Pre-Application Meeting (PRE18-064)

Site Location: 3675 WMW (3623500275, 362300274, 3623500273)

Brief Project Description: 3 parcels that are a consolidated lot and create 2 lots from 1 lot. Construct 2 homes (preliminary short plat application). The existing site currently houses a residence which will be partially demolished prior to the short plat in order to not present any non-conforming structures. No trees removal is proposed for this specific short plat submittal.

OGDEN POINT SHORT PLAT
DRIVEWAY PROFILE
THE LADYBUG TRUST
OGDEN POINT SHORT PLAT
SHORT PLAT APPLICATION
CITY OF MERCER ISLAND,
WASHINGTON

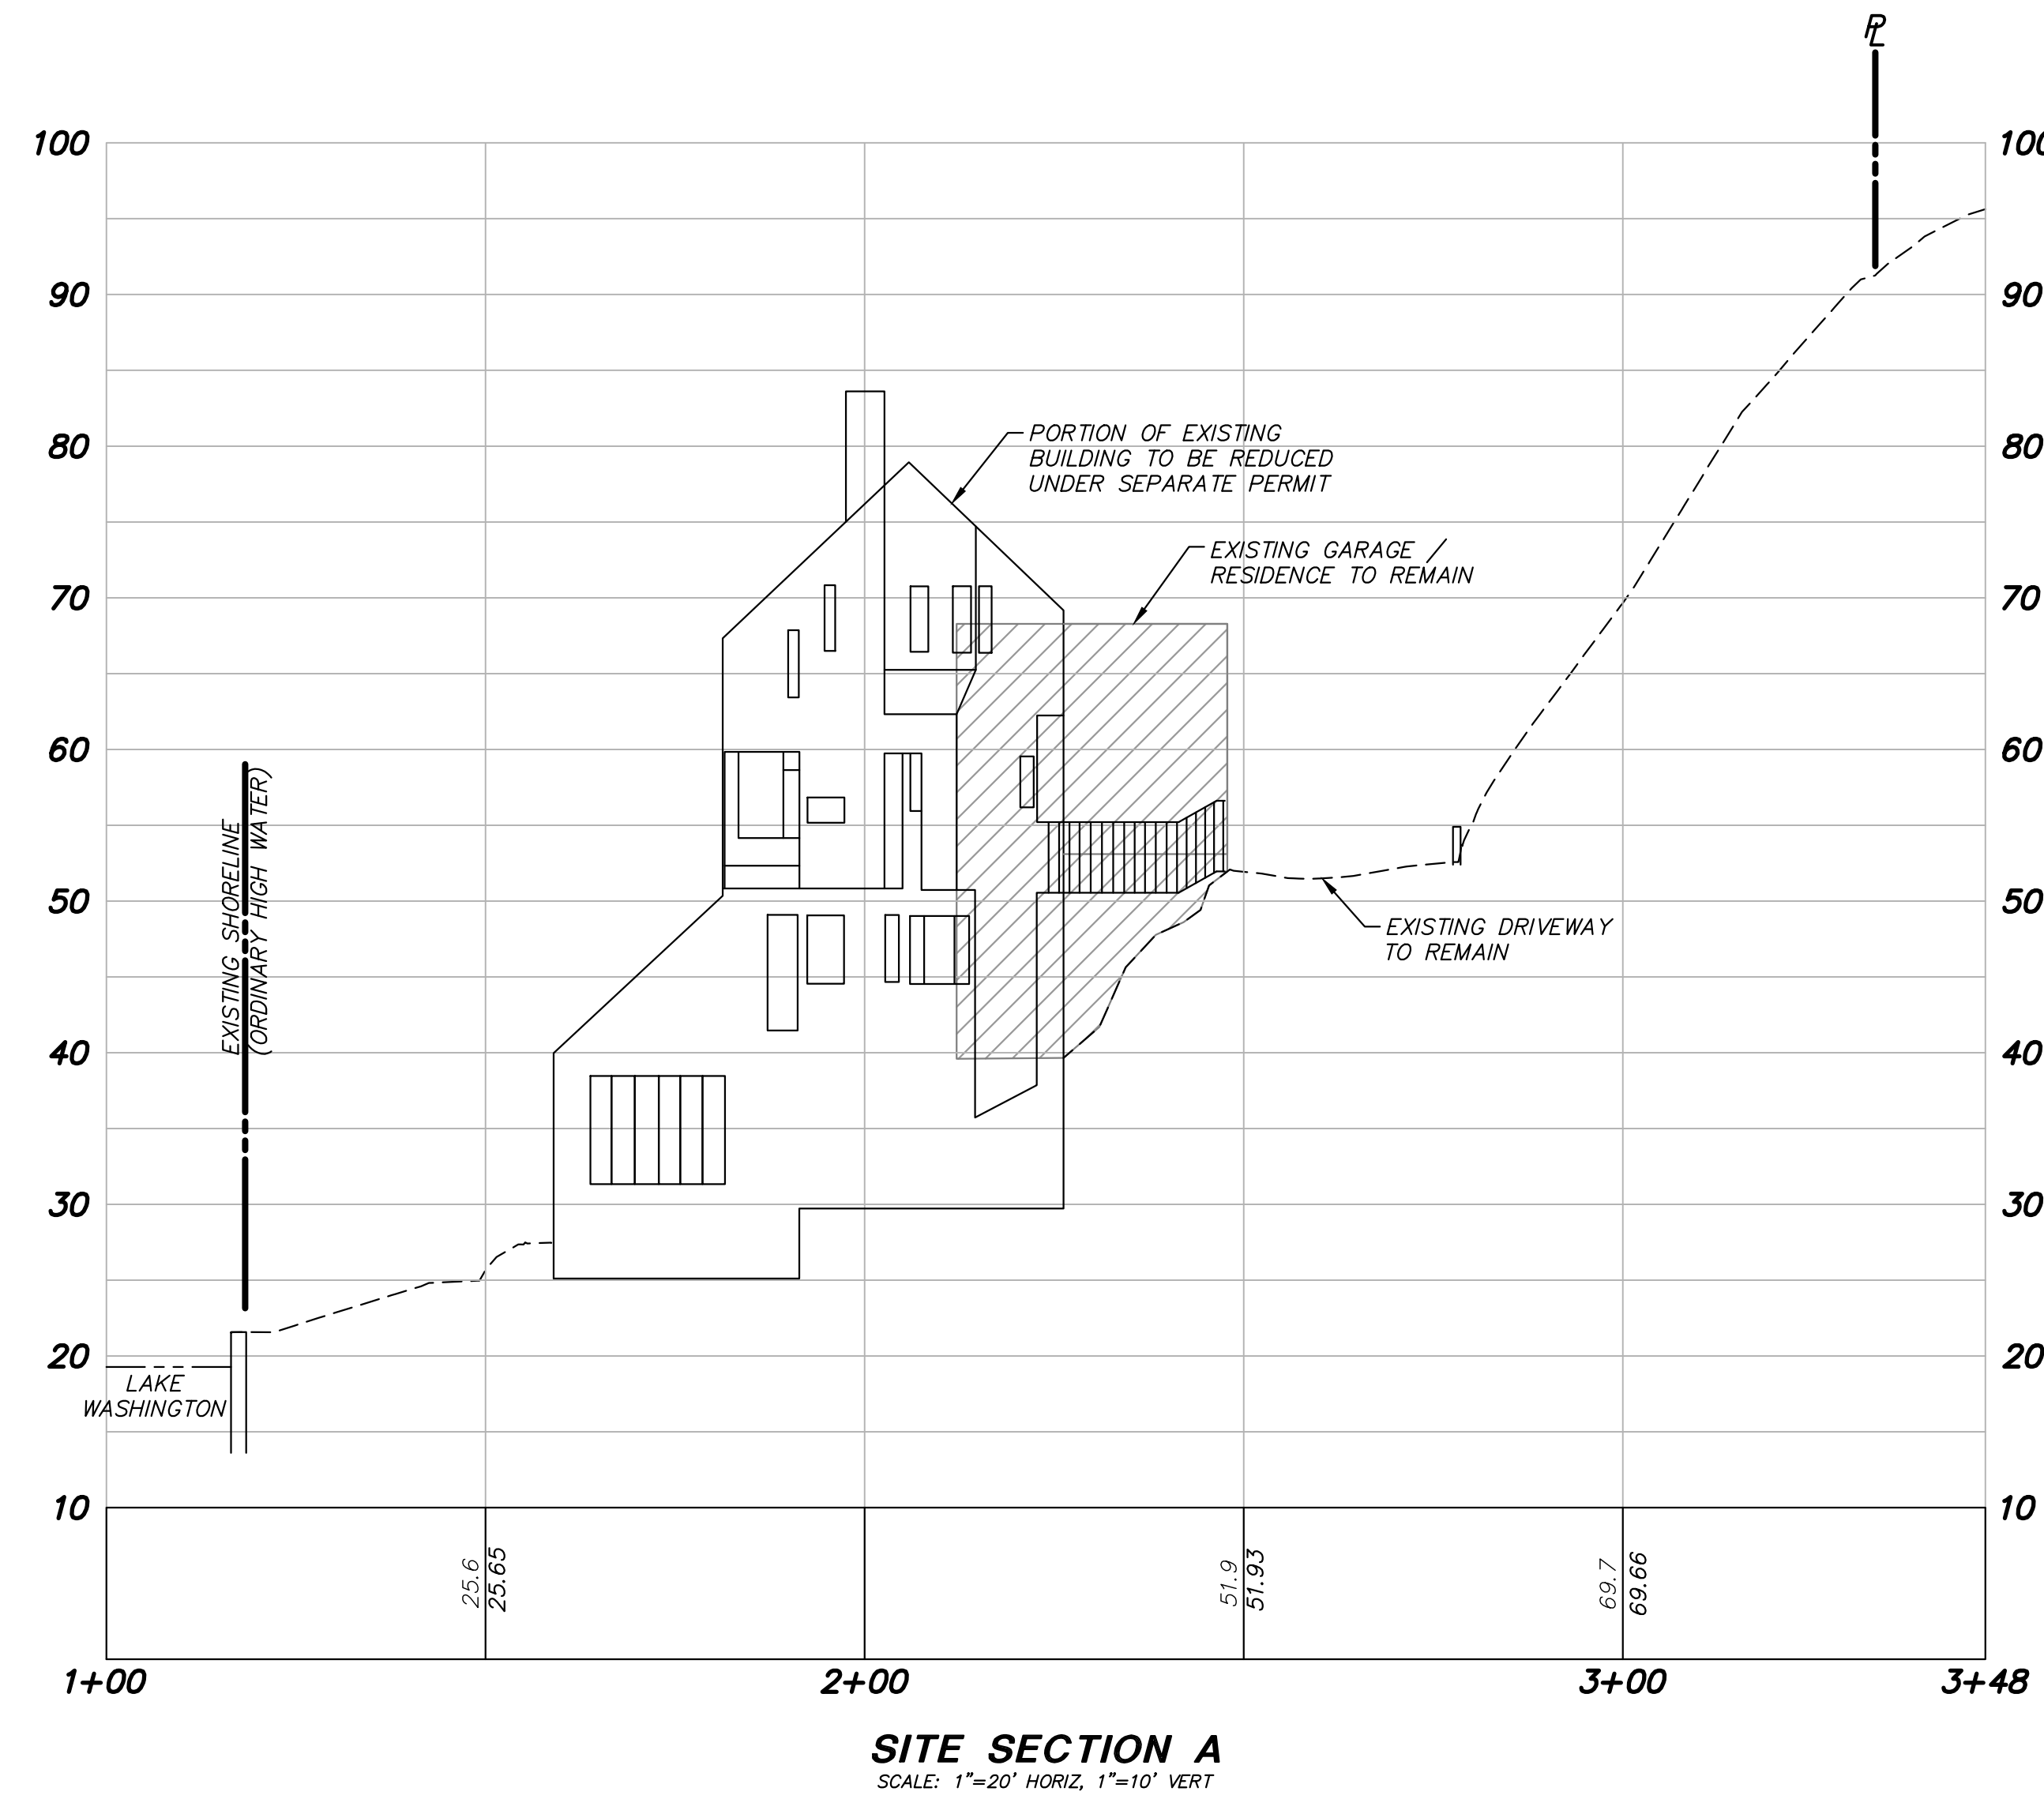
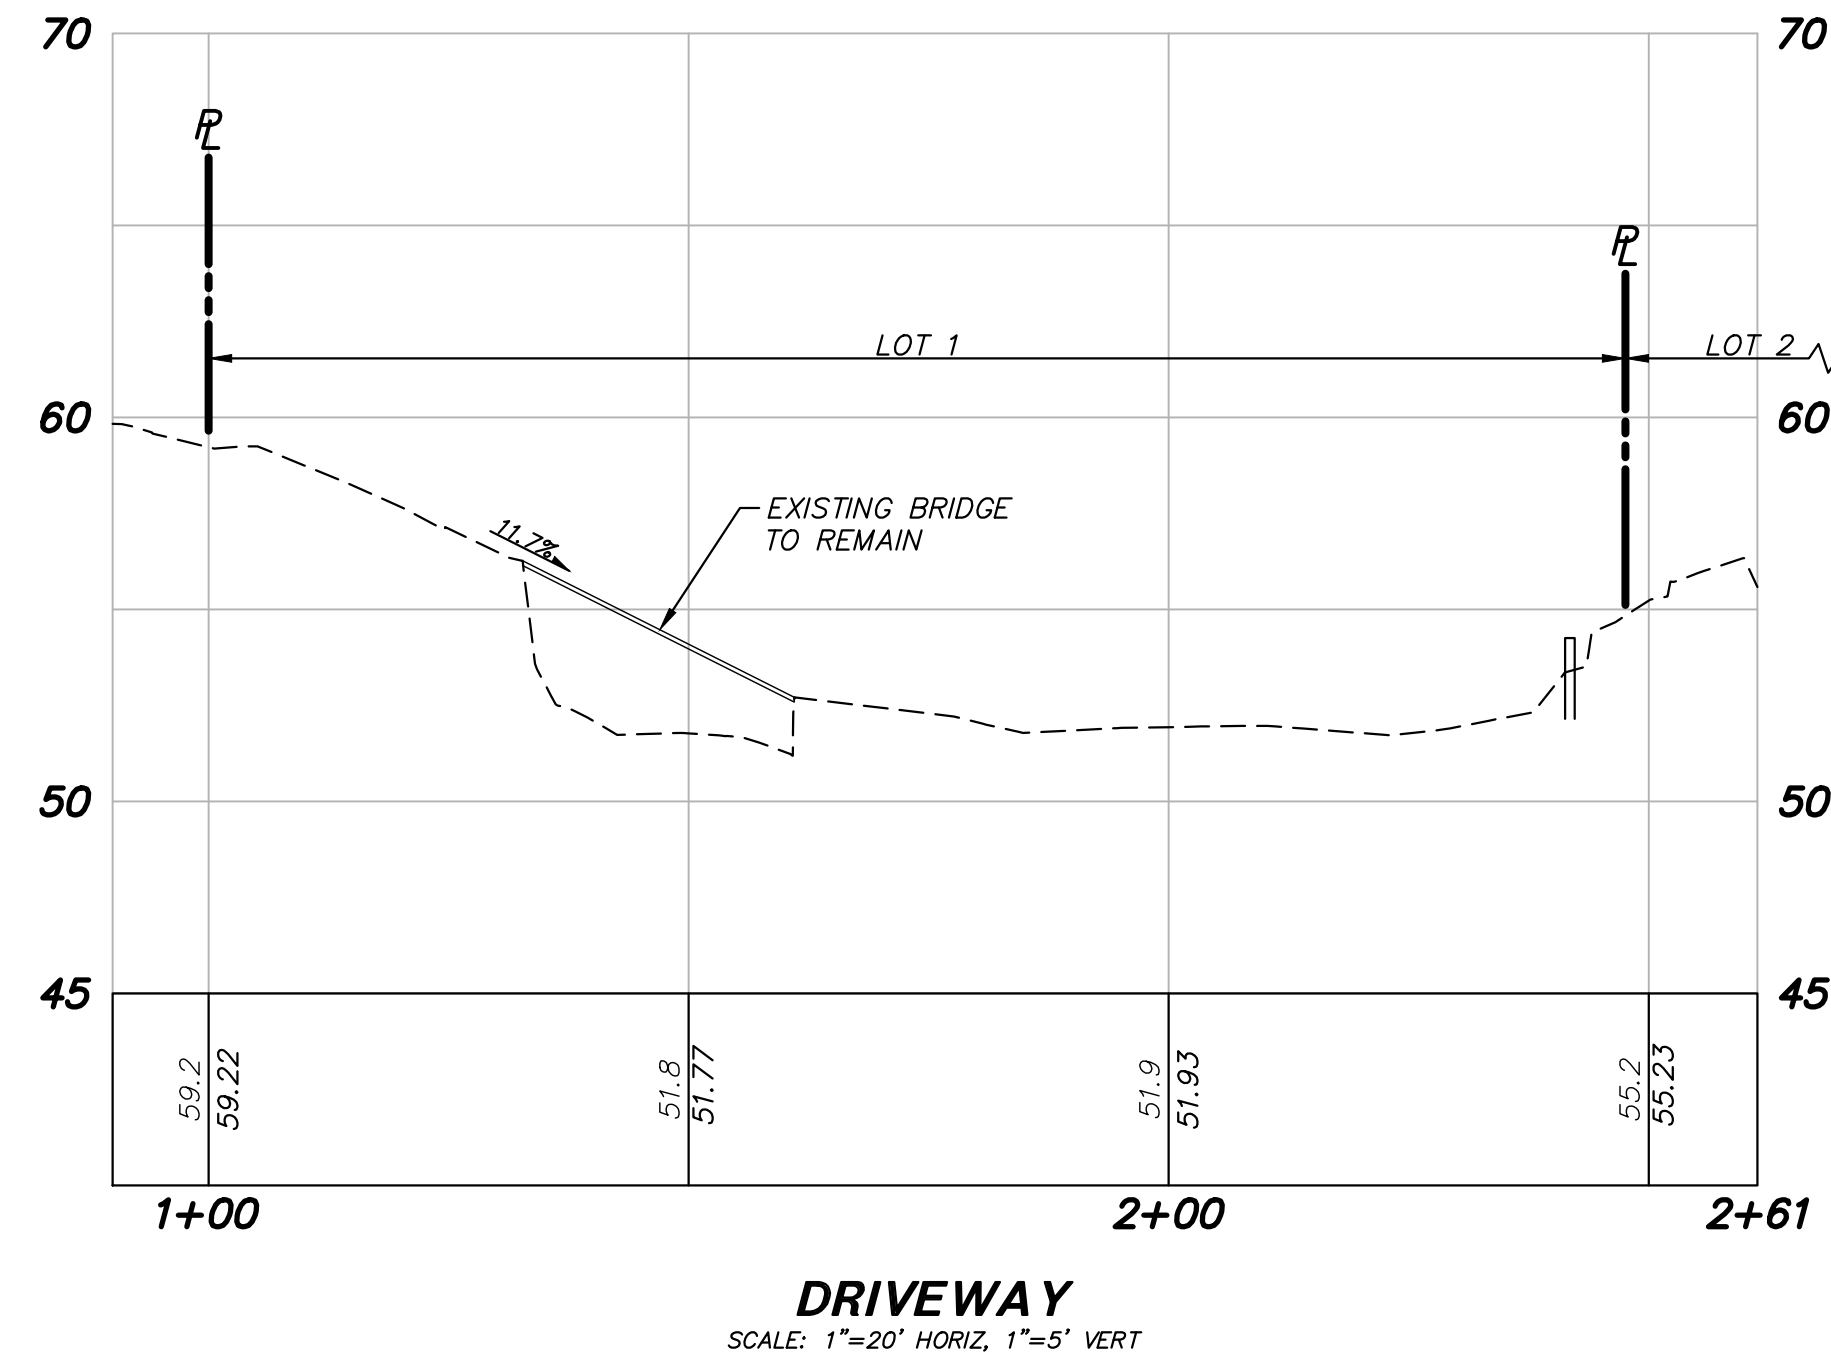
1. A fire turn-a-round is required because this road exceeds 150' in length. 2015 IFC Appendix D shows size requirements. Smaller sizes will likely be allowed with a code alternate request.
2. Bridge needs to meet weight ratings of 75,000pounds per D102.1 and 503.2.6.
3. The plan appears to show retaining walls adjacent to the driveway at Lot 2. Consider proximity and height of walls for use of access road.
4. Proposed construction of Fire Area of 10,000 SF or greater will require a fire hydrant.
5. The extreme level of deficiencies due to the road and hydrant distance may increase fire protection requirements regardless of size.
6. Providing home plans and a fire area calculation form will help determine Fire Code requirements for construction that may need to be considered at this stage in the project.

THIS SHORT PLAT APPLICATION DOES NOT PROPOSE ANY TREE REMOVAL. THIS PLAN IS INTENDED TO SHOW BUILDING PAD COMPLIANCE WITH TREE RETENTION REQUIREMENTS.

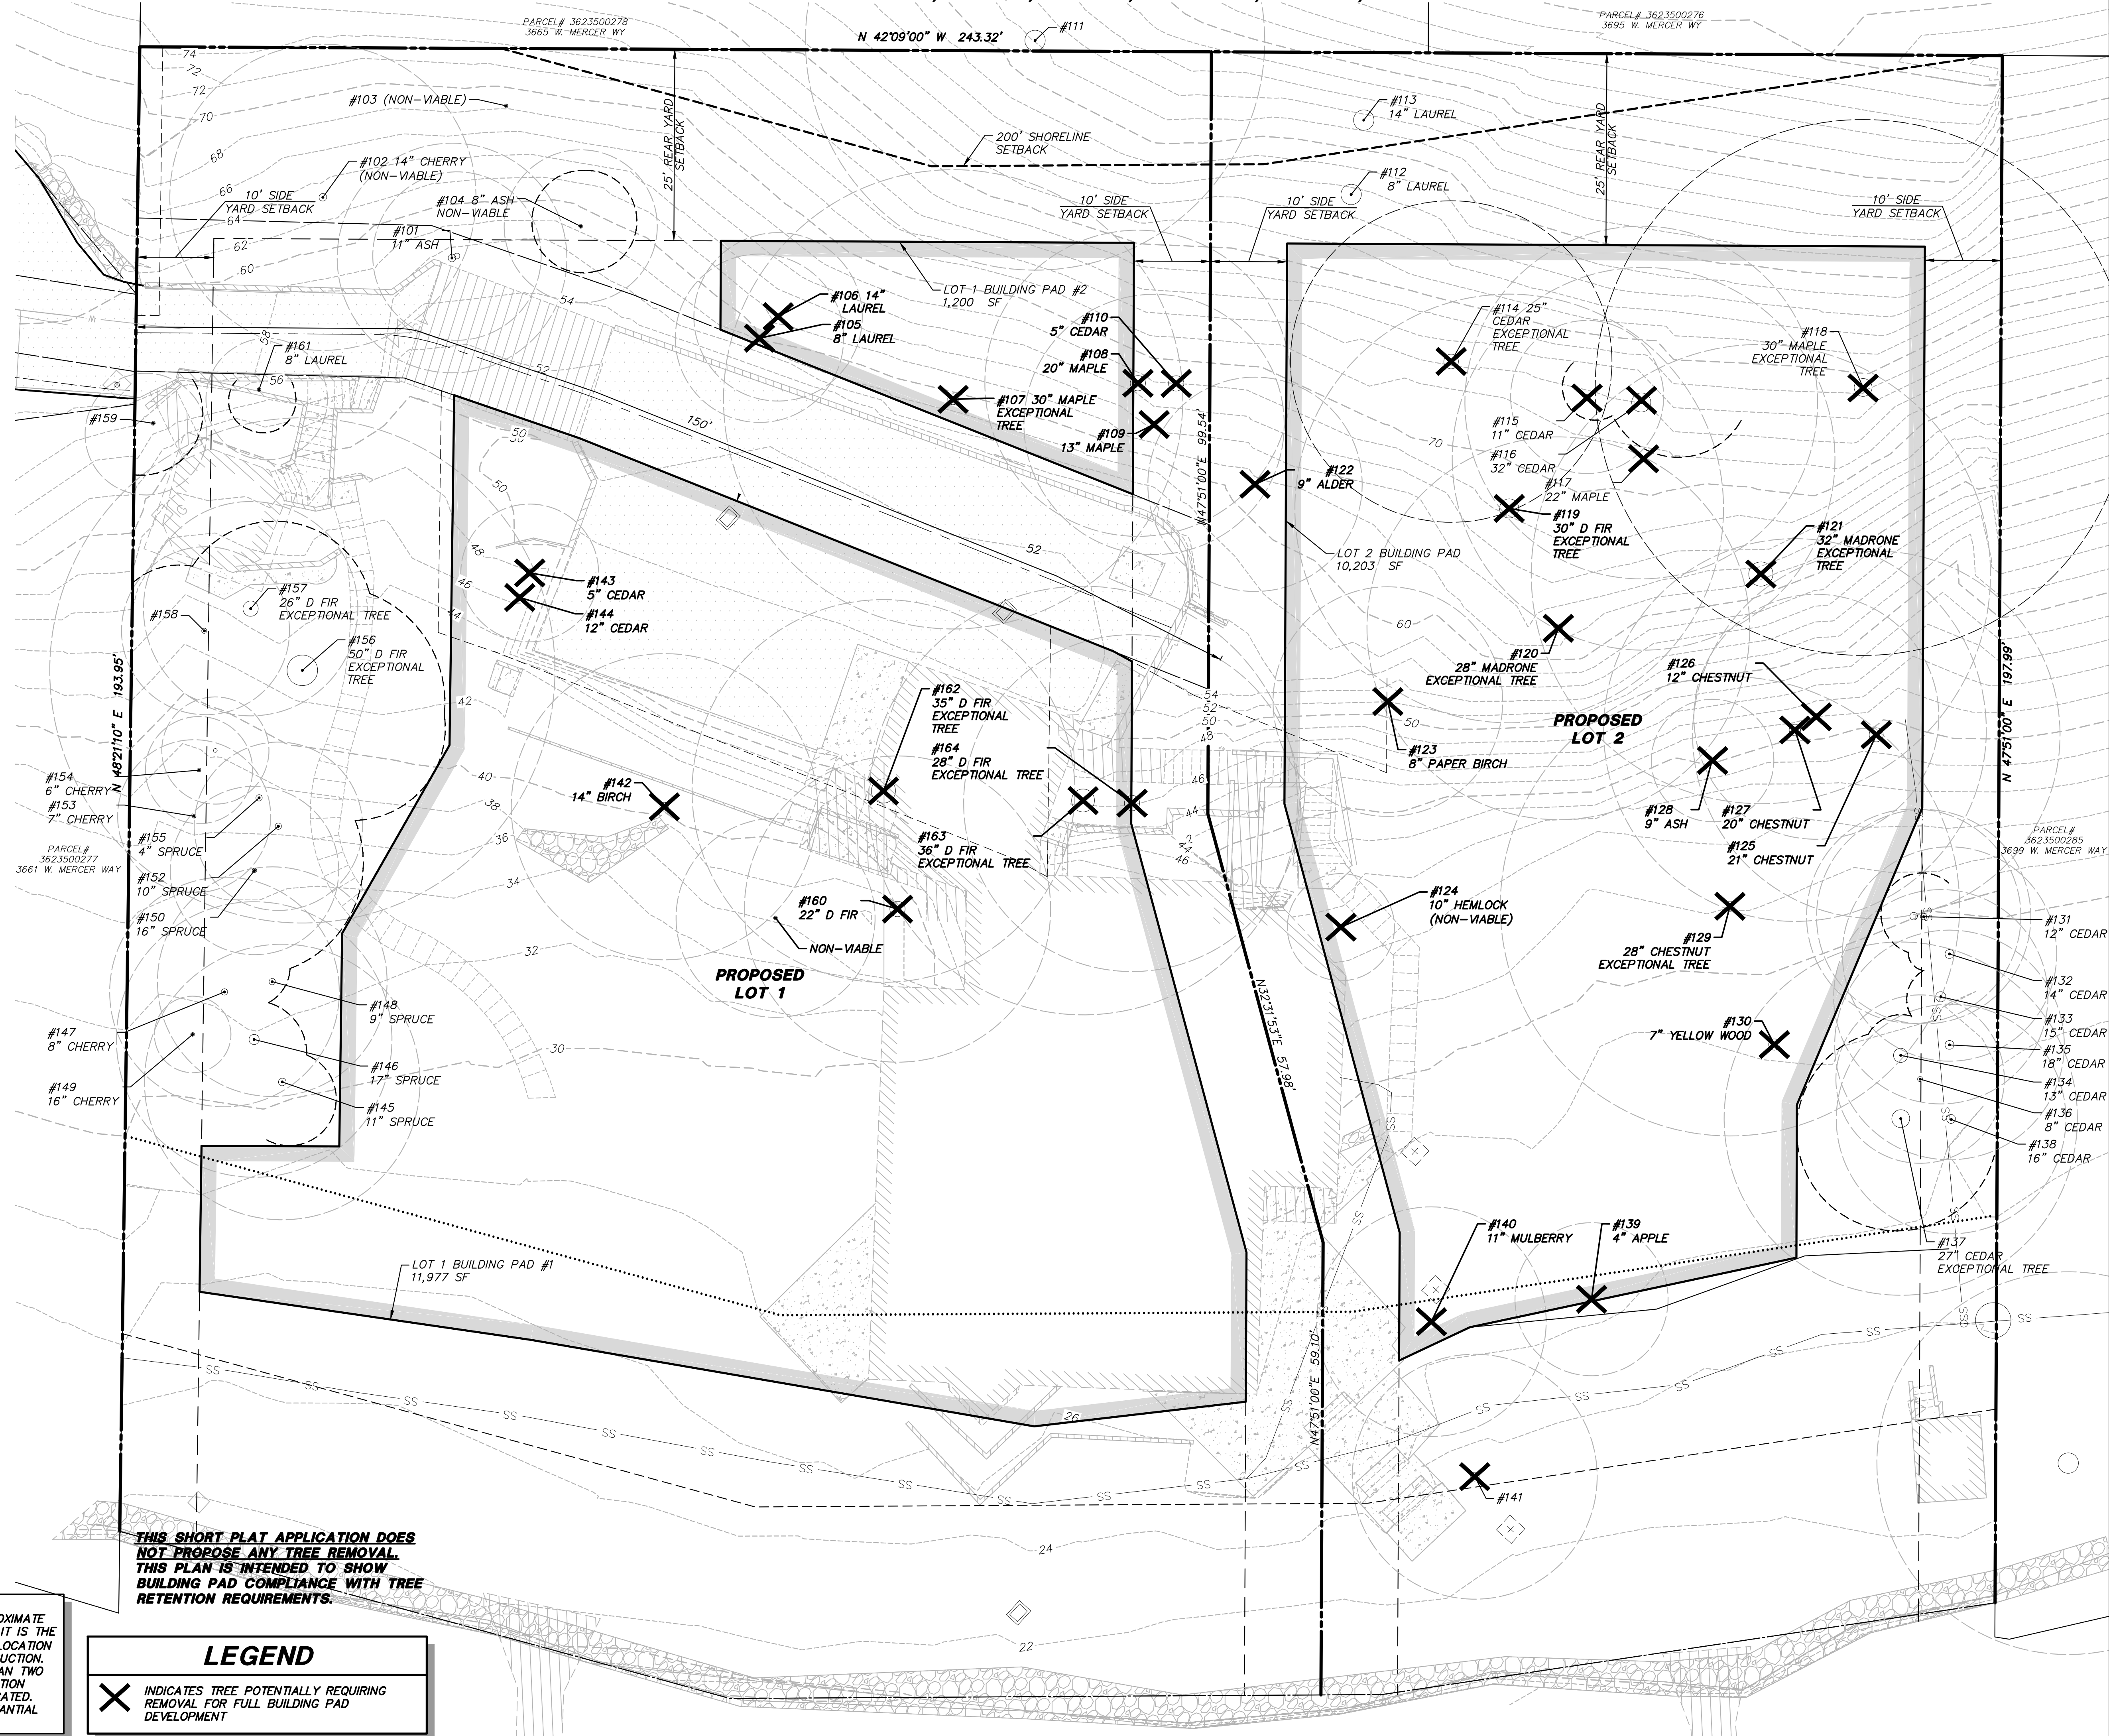
1. Update/amend year old Arborist report according to new plan. For instance, exceptional trees were proposed to be removed because of access/wall/demolition. Revise this plan according to newest proposal.
2. Show building pad with large exceptional trees being taken into consideration.
3. Propose new lot lines with exceptional trees into consideration.
4. Exceptional trees outside building pad/access shall be retained throughout construction and after unless shown to be hazardous.

- iv. No cross-section dimension of a building pad shall be less than 20 feet in width.
 - v. *Please note that the illustrated building pad areas on the proposed plat plans are incorrect. The ones shown look to be proposed building footprints, not the building pad area. This building pad area will be recorded with the plat and will be used for future reference on the buildable area on the lot. Thus, it is important to illustrate the correct building pad area size as it will affect future development.
